August 1, 2012

RE: Harnett County Land Use Existing Tank Application #12-5-28928

Harnett County Department of Public Health Site Sketch

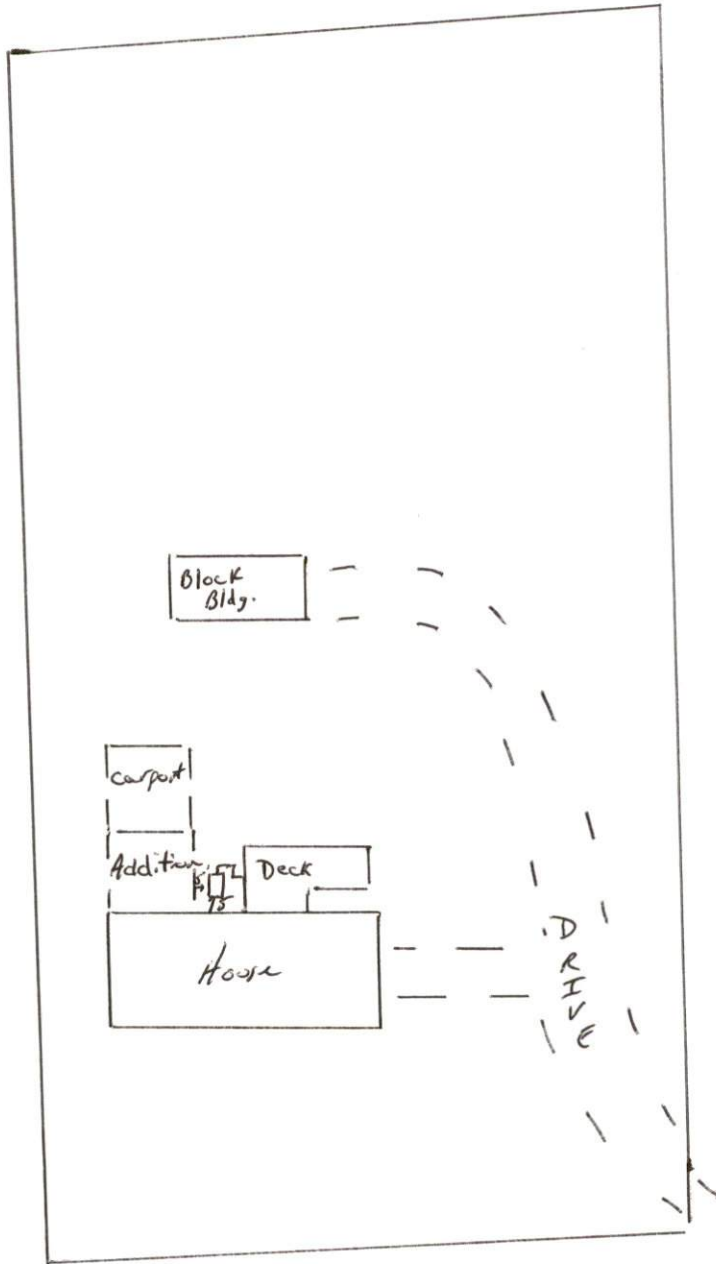
Based on the criteria set out in Title 15A, Subchapter 18A, of the North Carolina Administrative Code, Rules .1950, the evaluation indicated that the site is **UNSUITABLE** for the addition requested. Therefore, your request for an existing tank is **DENIED**. The site is denied based on the following:

- 15A NCAC 18A.1950a {16} - Any swimming pool must be 15' from any part of septic system.
- 15A NCAC 18.1945{b} - Each lot shall have original septic system plus repair area.
- 5A NCAC 18A.1950 {10} - Any building to be 5' from septic tank and/or from drain line.
- 15A NCAC 18A.1950{c} - Nitrification fields and repair areas shall not be located under paved areas or areas subject to vehicular traffic.
